KITTITAS COUNTY COMMUNITY DEVELOPMENT SERVICES

RE: Williams Country Estates Short Plat (SP-09-00016)

The Kittitas County Community Development Services Department has determined that the Williams Country Estates Short Plat (SP-09-00016) is a complete application and hereby grants *conditional preliminary approval* subject to the following conditions:

WILLIAMS COUNTRY ESTATES SHORT PLAT
 PART OF SECTION 11, T. 18 N., R. 19 E., W.M.
 KITITAS COUNTY, WASHINGTON

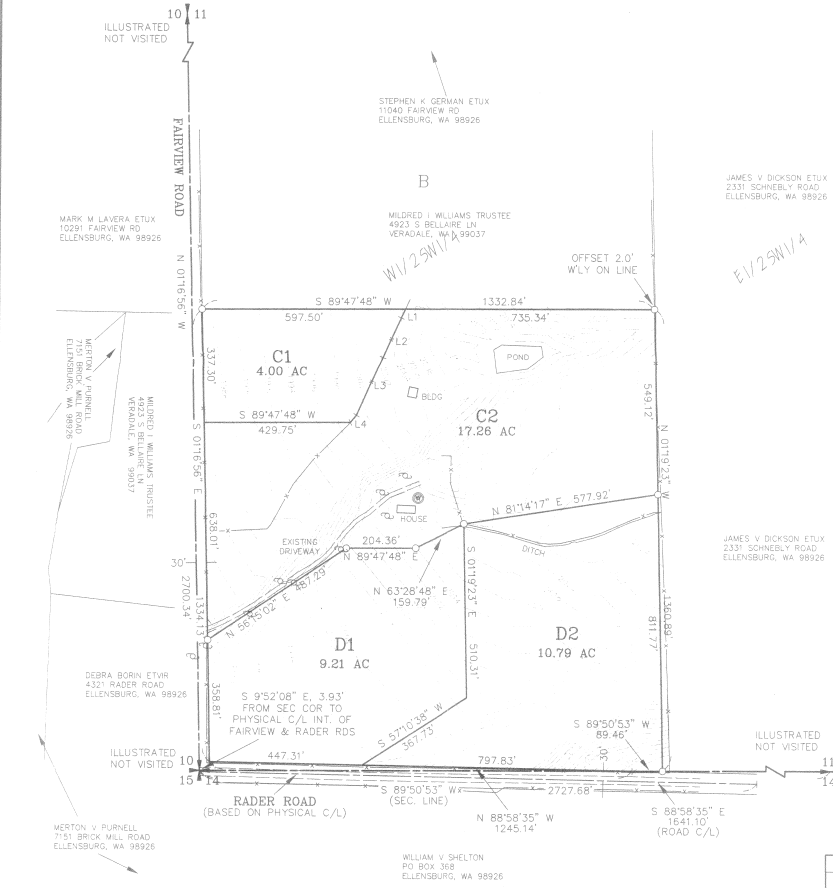
1. Both sheets of the final mylars shall reflect short plat number SP-09-00016 and an accurate legal description shall be shown on the face of the final plat.

9. Lot C2 of the Williams Country Estates Short Plat has a PUBHH wetland in the northeast of the property surrounding the pond. The Final mylars shall reflect the location of this wetland and a statement on the plat shall read as follows: "Future development of lots may require a study by a certified wetland biologist to determine wetland classification and for buffer requirements pursuant to KCC Critical Areas Code."
